## Appeal Decision

**Appeal Ref: APP/R5510/D/21/3280568**

**14 Nicholls Avenue, Uxbridge UB8 3JL**

- The appeal is made under section 78 of the Town and Country Planning Act 1990 against a refusal to grant planning permission.
  - The appeal is made by Mr Mohammed Haji against the decision of London Borough of Hillingdon.
  - The application Ref 788/APP/2021/1573, dated 20 April 2021, was refused by notice dated 15 June 2021.
  - The development proposed is a single rear/side extension and all associated works.
-

Proposed Ground Floor Plan

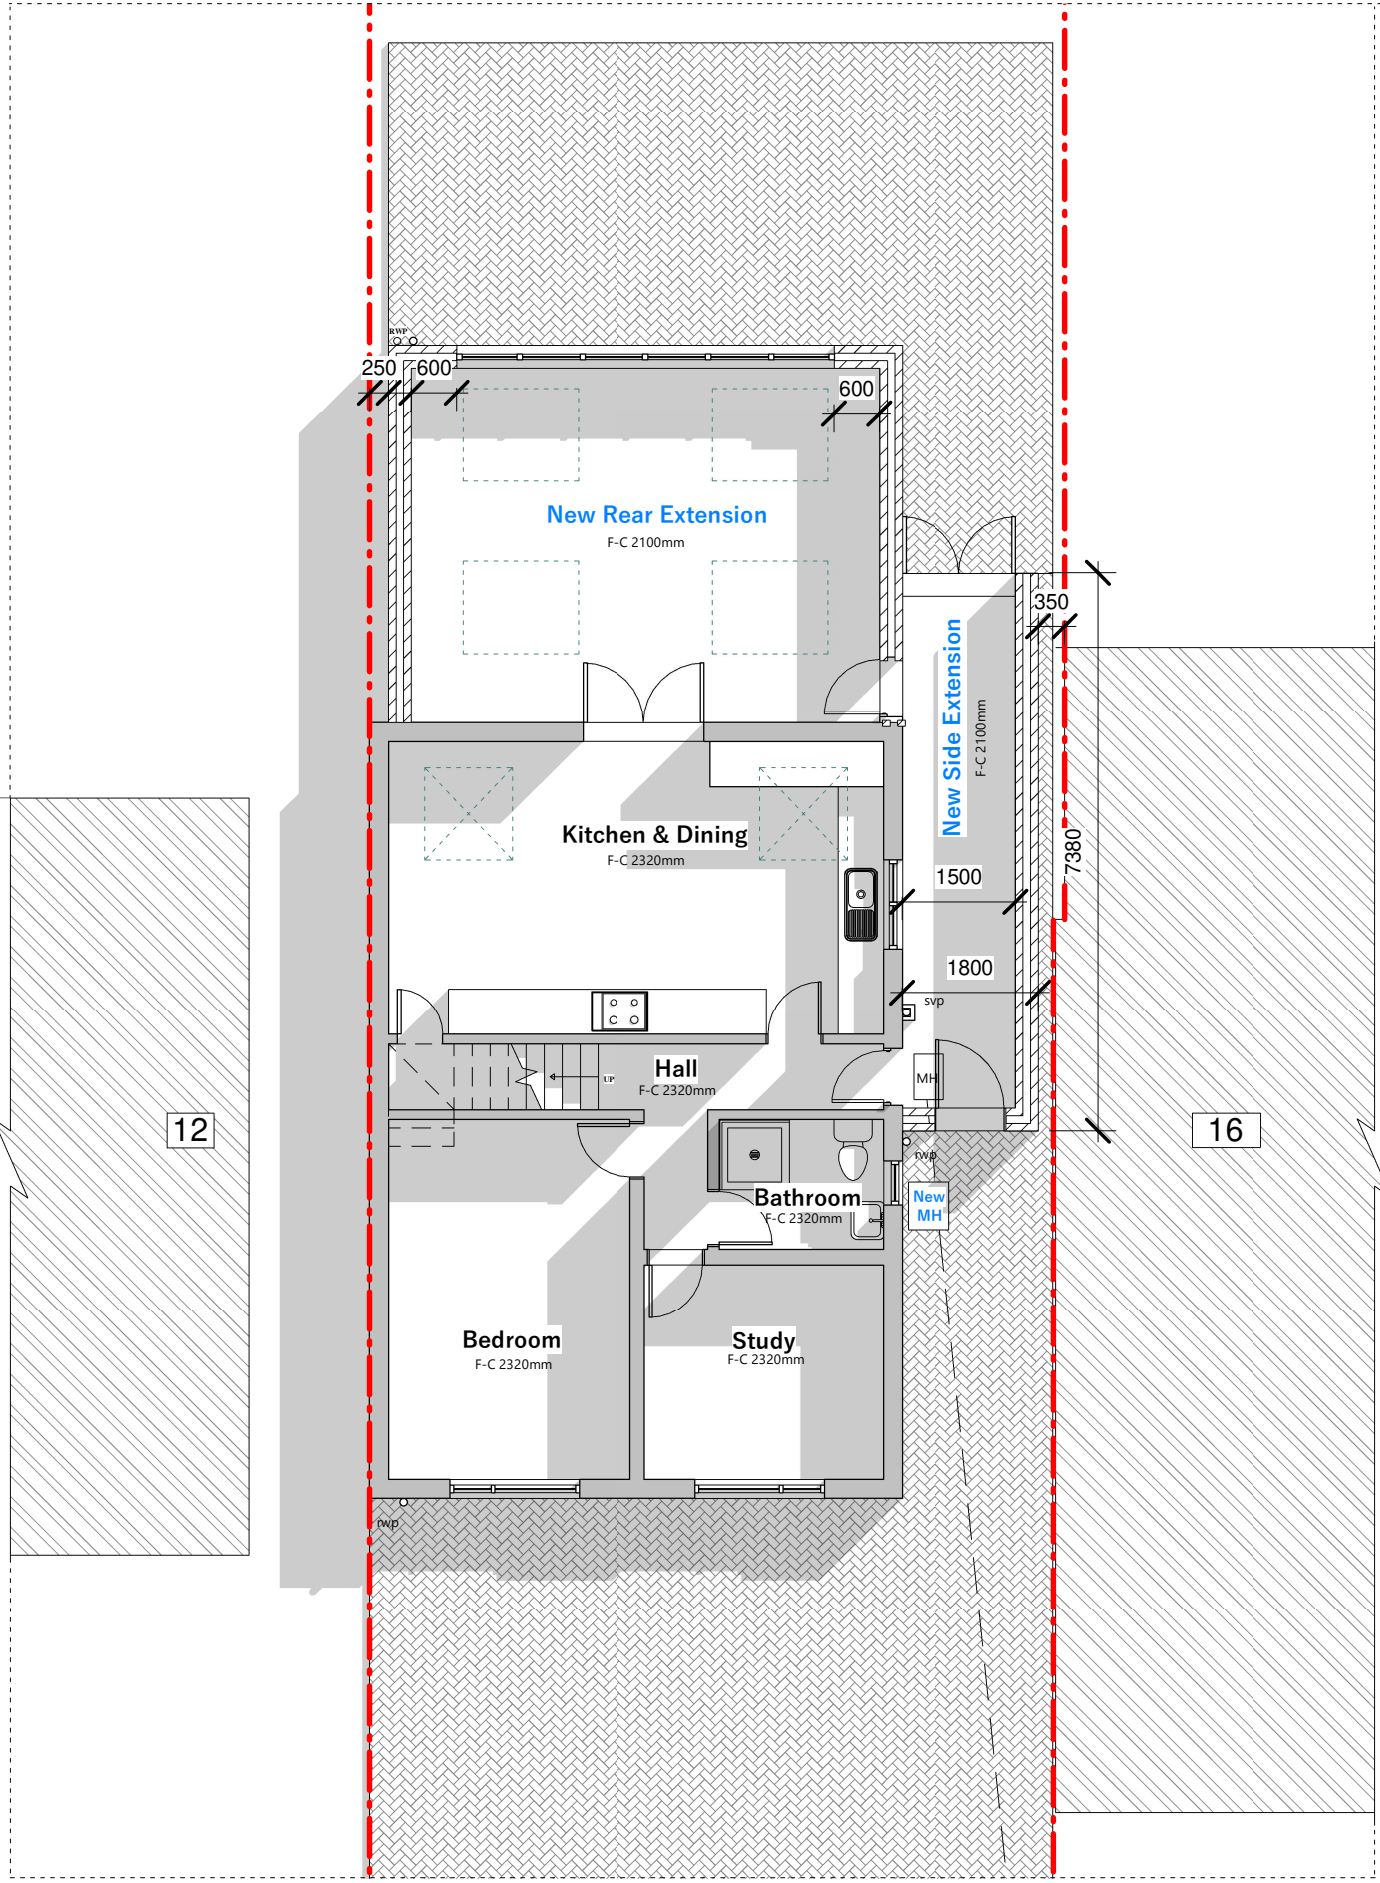
9. The submitted plans show that the proposed extension would extend from the rear elevation of the appeal property by 5 metres and would be the full width of the property, in addition to a side extension. I note that the plans have been amended from earlier iterations with the reduction in the length of the extension and the replacement of the pitched roof with a flat roof. Nonetheless the appeal scheme is substantial in itself and in proportion to the appeal property.

20. The submitted plans show the proposed extensions wrapping around the rear and part of the side elevation of the appeal property. As a result, the room labelled as 'Kitchen & Dining' would become a largely internal room without traditional external windows. The plans do however include two rooflights that would provide some daylight, nonetheless very limited outlook would be provided by the roof lights.

22. Furthermore, the appellant suggests that the main room of the extension and the 'Kitchen & Dining' could be merged. However, that proposal is not before me and I have based my decision on the submitted plans. That a condition could be attached to any permission resulting from this appeal is also suggested. No wording of such a condition has been provided and I am not clear as to how a condition could resolve this matter.

23. On the basis of the evidence before me I am satisfied that in the absence of traditional external windows and while acknowledging the two rooflights, the appeal scheme would fail to provide acceptable living conditions for the future

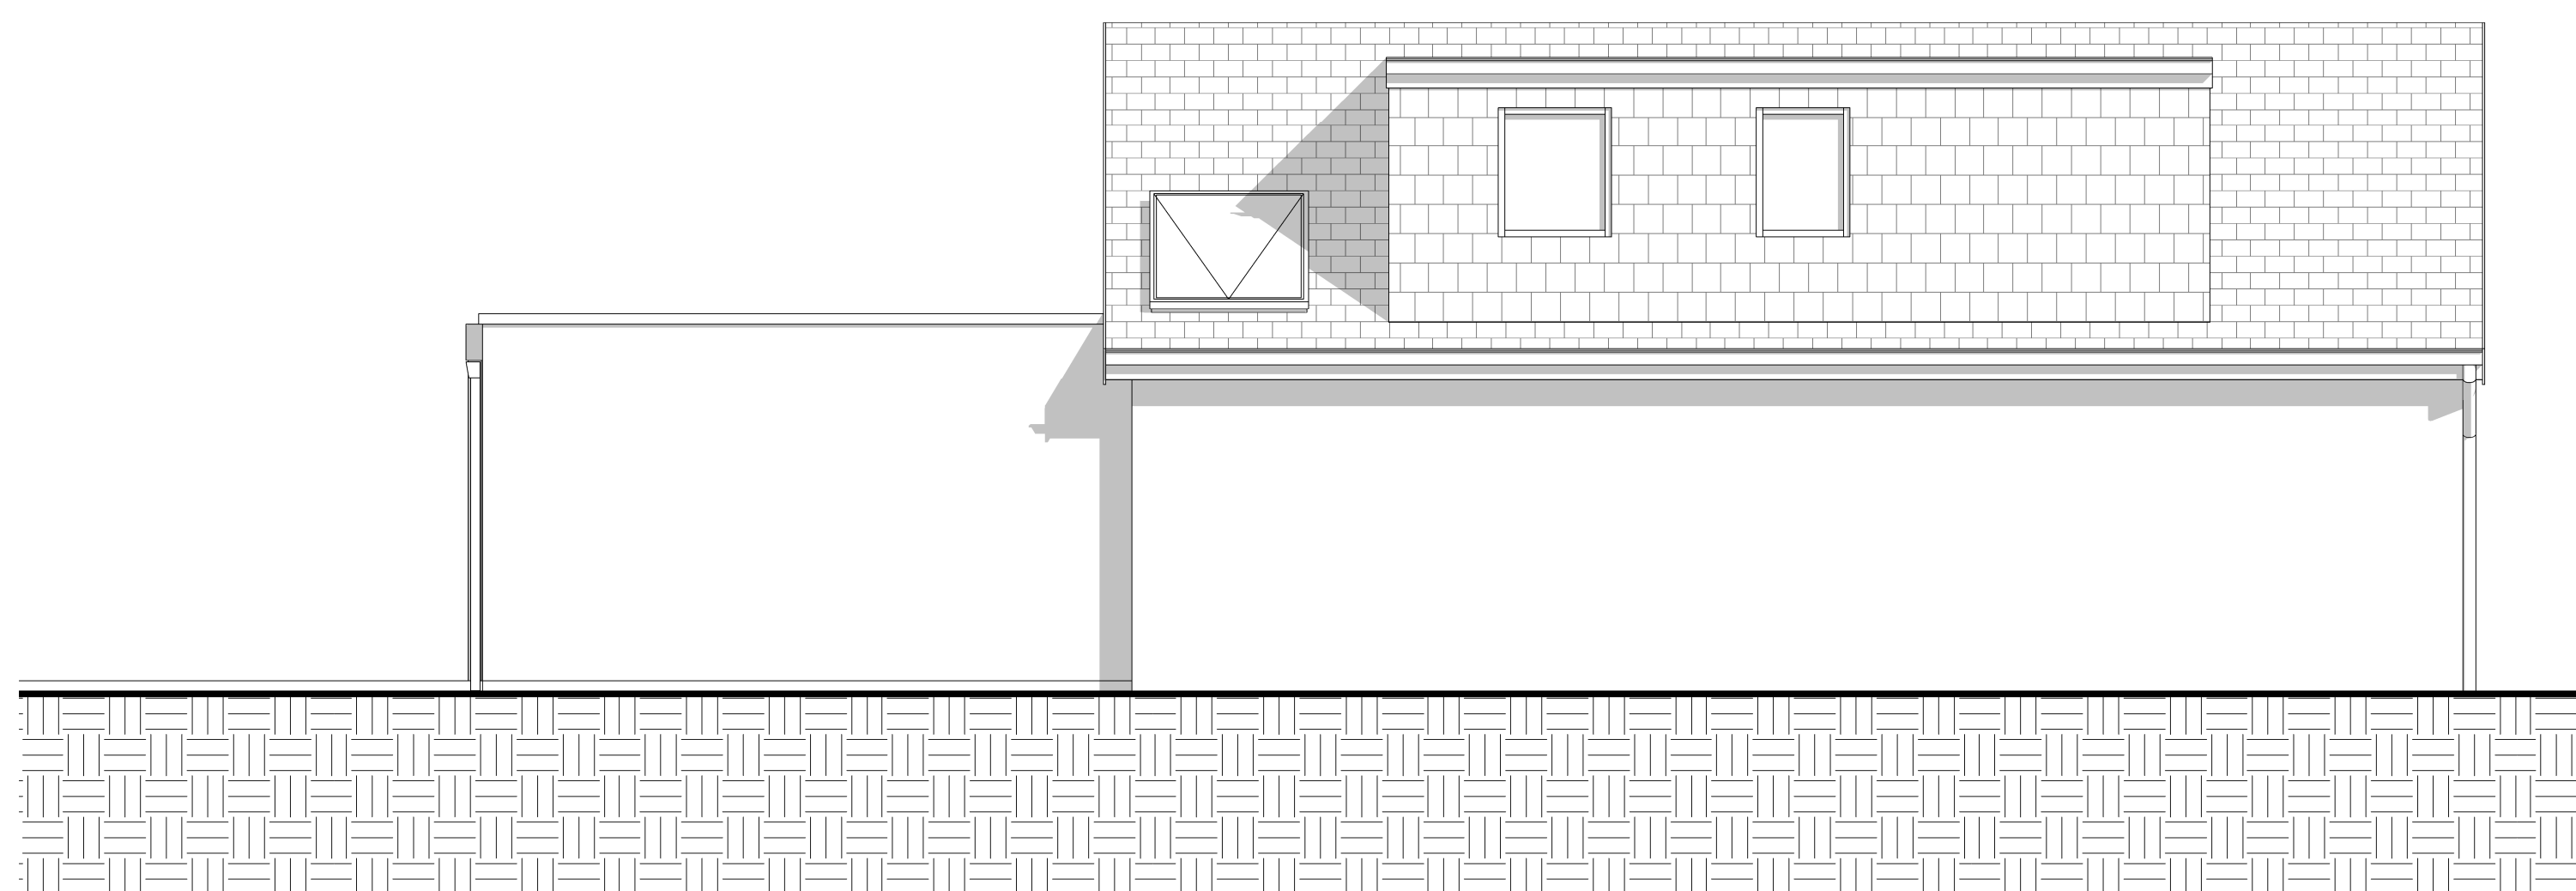
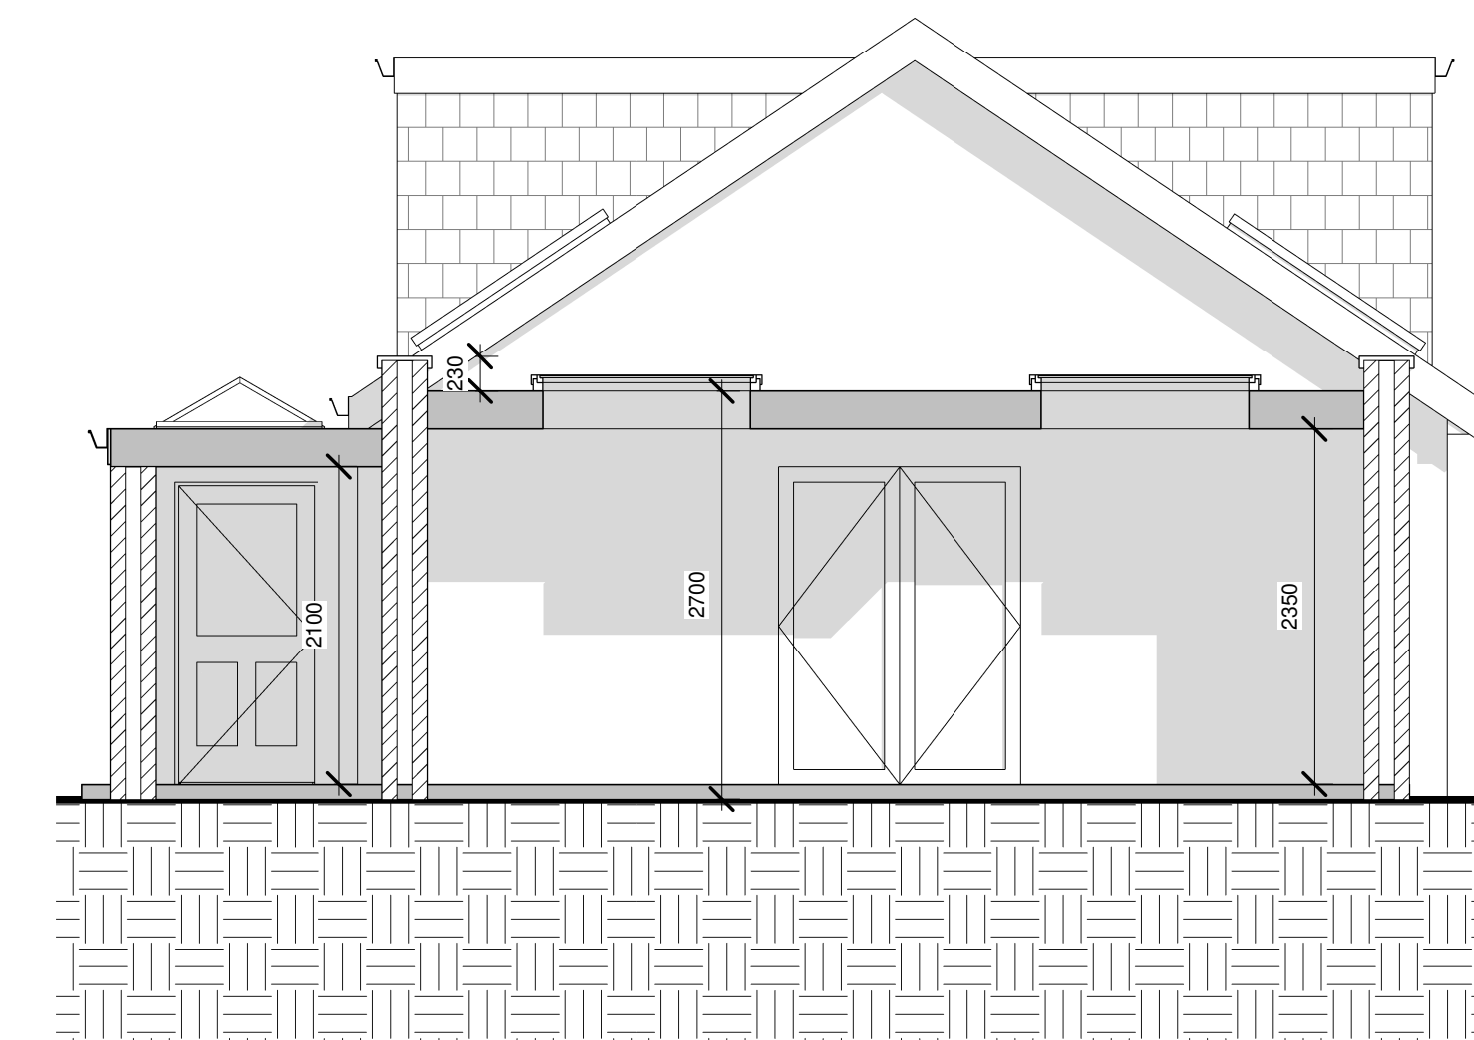
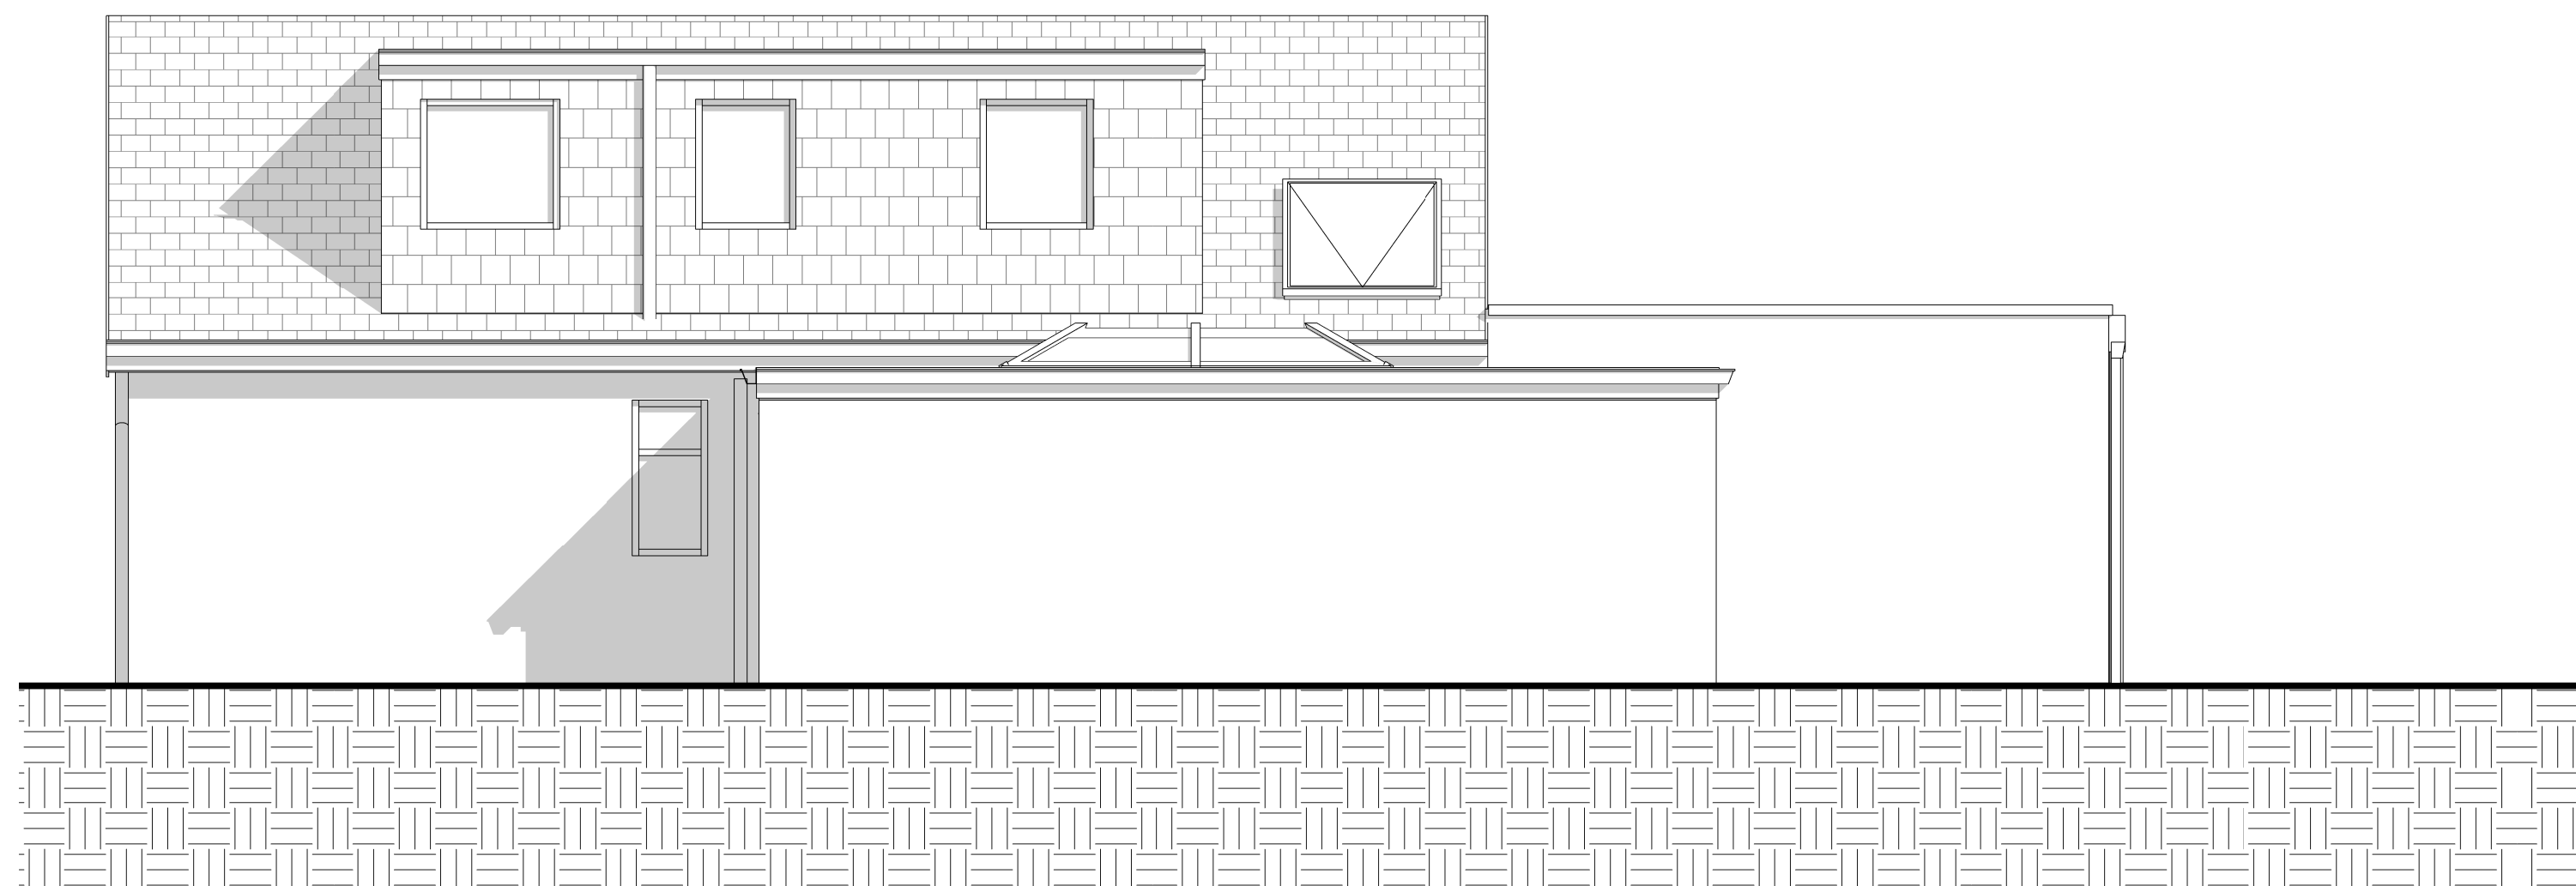
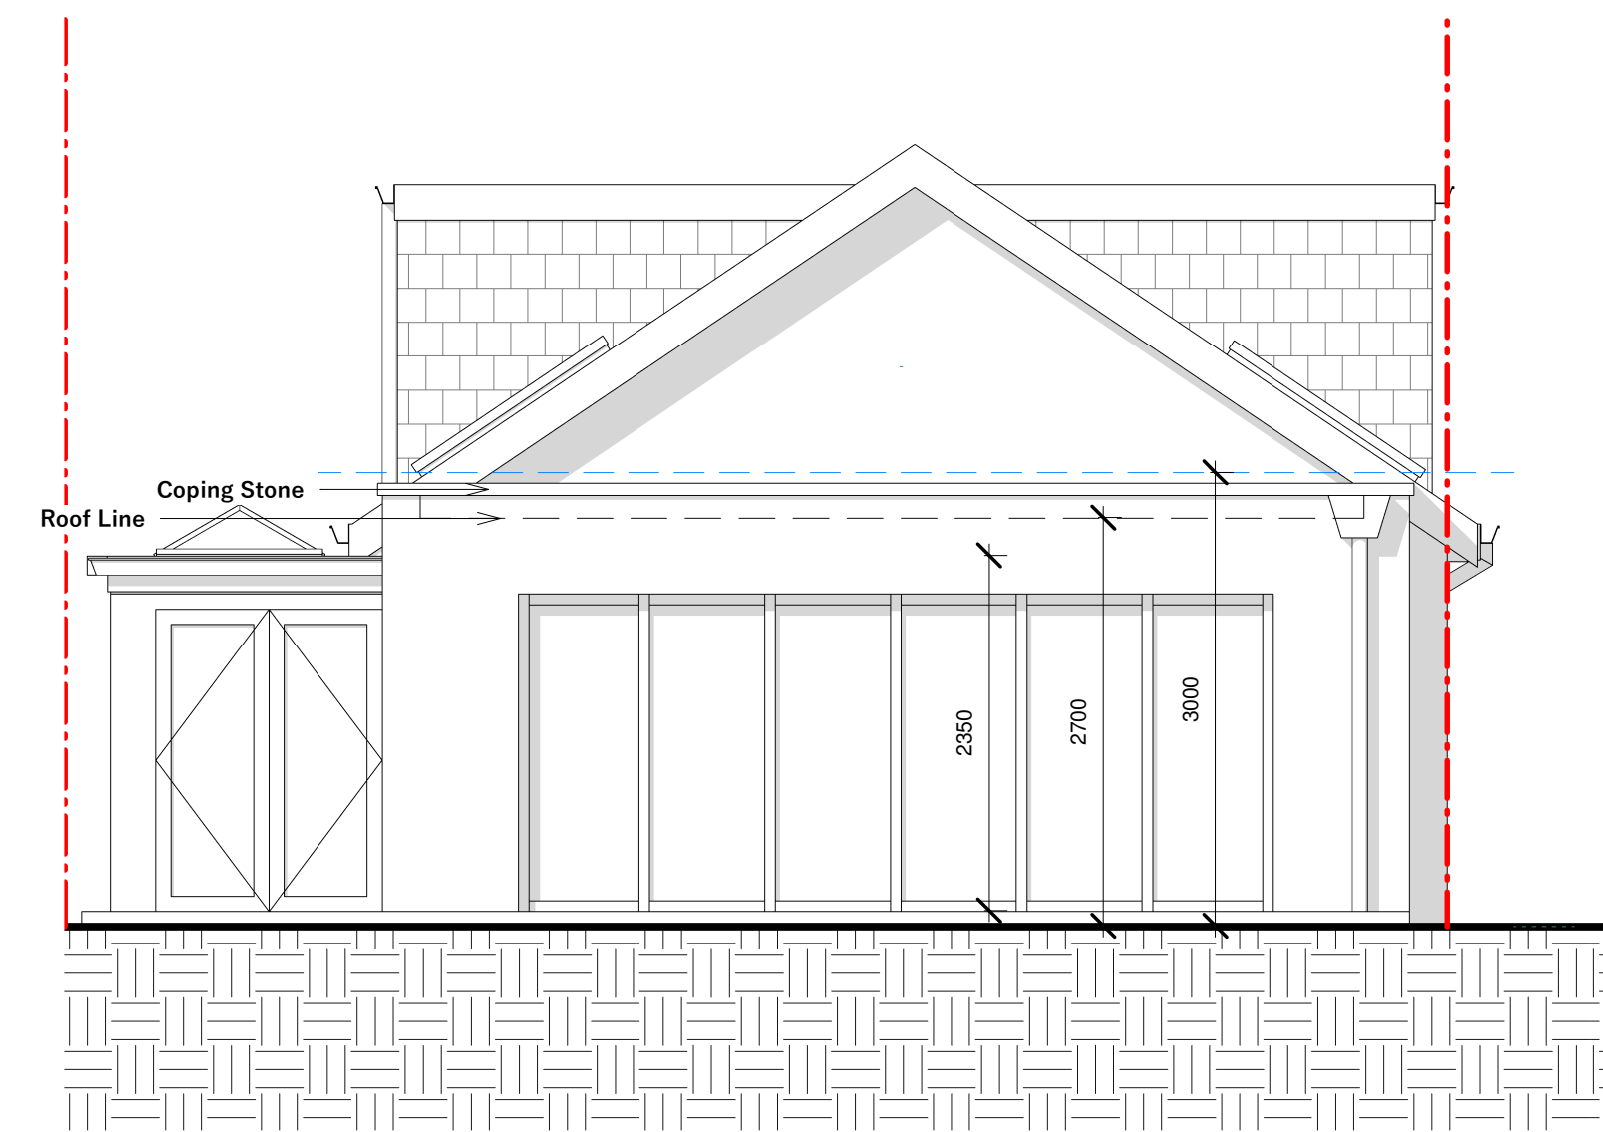
10. At the site visit I saw that many properties in the local area have been subject to various extensions but by no means all properties, the area and appeal property still retained the overall character of modest dwellings set within their own respective well-proportioned plots. The proposed development, as shown on the submitted plans would envelop the appeal property fundamentally changing the character and appearance of the property harming the character and appearance of the area.

12. Policy DMHD 1 of the DM requires that, amongst other matters, rear extensions to detached houses should not exceed 4 metres in depth.
13. The appeal scheme would project some 5 metres along the shared boundary with 16 Nicholas Avenue from the rear elevation of the appeal property that is situated approximately level with the rear elevation of the No.16.
14. In support of the appeal the appellant has detailed that the proposed extension would project 4m from the rear wall of No.16 and that "the 45-degree sightline is not infringed". While clearly stated, no substantive evidence has been provided to support this assertion and at the site visit I saw that there were windows in the rear elevation of No.16 adjacent to the boundary with the

appeal site. As such I am not satisfied that it has been demonstrated that the appeal scheme would not break the "45-degree line".

17. As a result of the significant projection of the proposed extension beyond the rear elevation of the appeal property and that of No.16, the appeal scheme would result in unacceptable harm to the living conditions of the occupiers of that property with particular regards to outlook and overshadowing.
